## **NEW EPPING SOUTH PRIMARY SCHOOL ( CONCEPT & STAGE 1)**

**Application No SSD:** SSD-8873789

**Location:** 86 Chelmsford Ave, Epping NSW 2121

### **REASONS FOR NOT SUPPORTING THE DEVELOPMENT (UPDATED)**

Figure 27 | DOPU zone (in green) (Source: Applicant's RtS 2021)

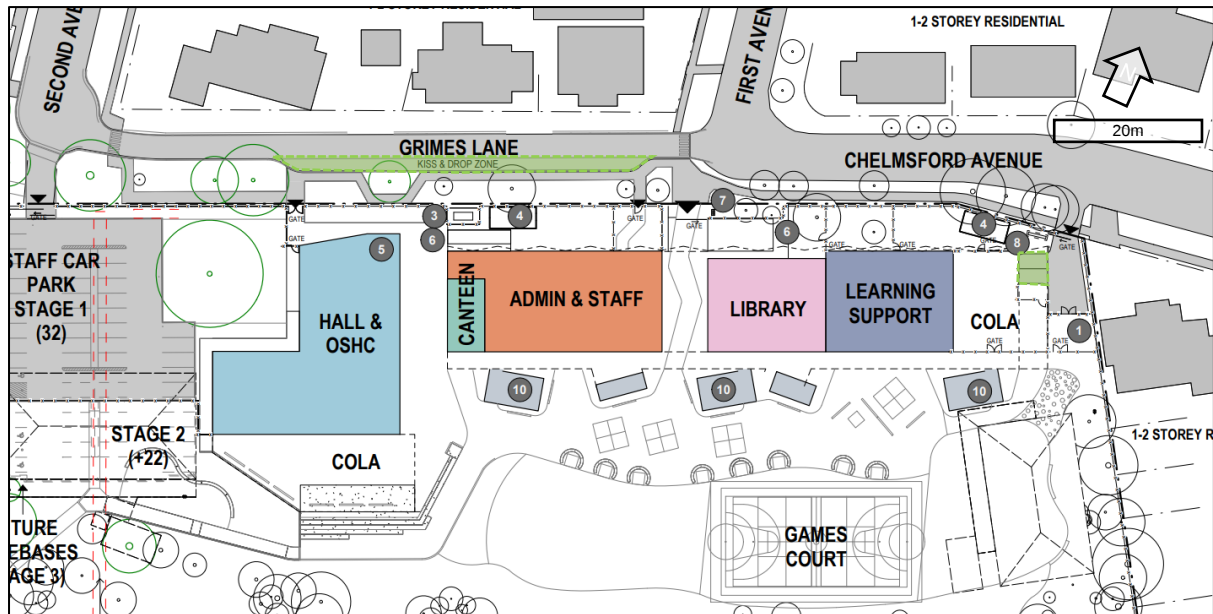
- f. The proposal also puts parking entries right up next to and in front of residential houses instead of maintaining the current parking entry at the corner of the street.

- h. The proposal also puts parking entries right up next to and in front of residential houses instead of maintaining the current parking entry at the corner of the street.

Figure 34 | Stage 2 and Stage 3 locations as currently proposed (Source: RtS 2021)

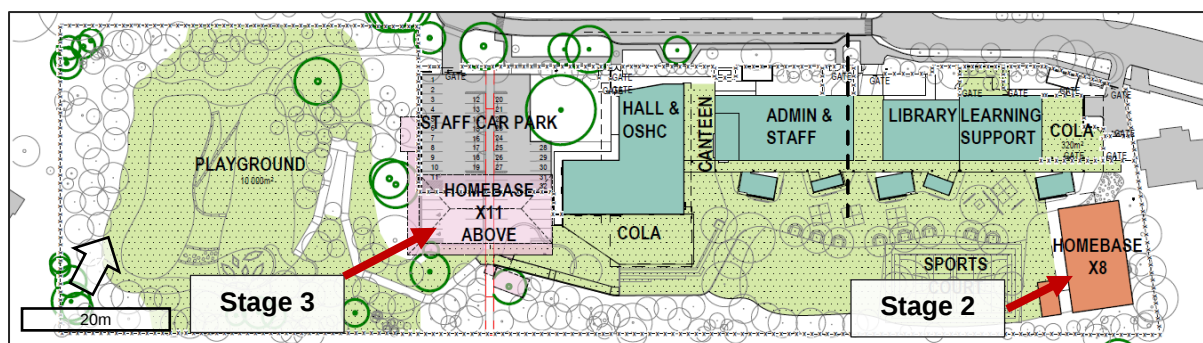
- a. Three storey high buildings with heights estimated above 12.5m, have been concentrated against the north-east corner of the site against single/double storey residential housing.
- b. Such high building heights should be moved to the back of the site against the residential apartment blocks to be more consistent with height scaling across the site. The front of the site along Grimes Lanes and to the side adjoining 848 Chelmsford should be built with equivalent height to single storey residential.
- c. The building envelope across the site should be more evenly distributed across the full site and utilise the current tree canopy for shading in order to reduce the site's increased radiant heat transfer from the new buildings.

Figure 35 | Trees to be removed on site (red circles) (Source: RtS 2021)

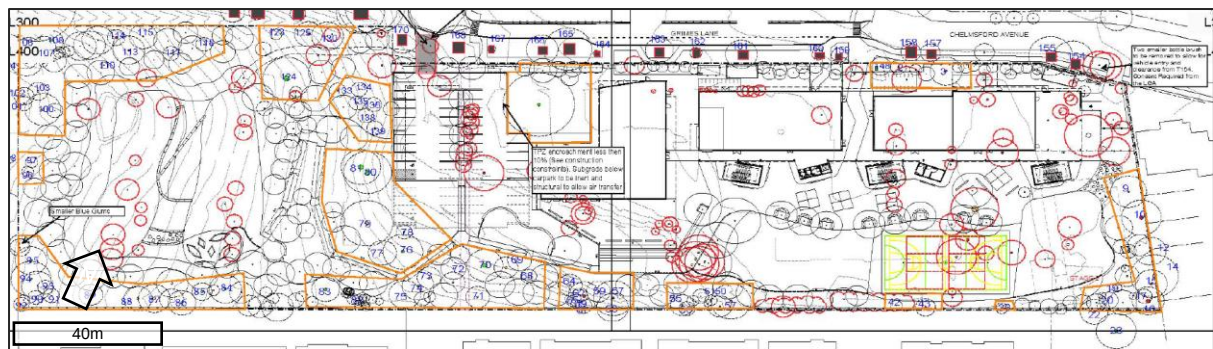
- c. The updated development footprint proposed does not prioritise the sensitive species of trees and fauna that are at the site. The revised proposal only clarifies the removal of trees. The trees are well established and diverse in their selection and should be saved.

- e. The current development plan requires a significant proportion of the trees closest to the street and houses be removed. Removing any trees from this site will significantly change outlook and environment on Chelmsford Ave and Grimes Lane so the development proposal should take this into consideration.
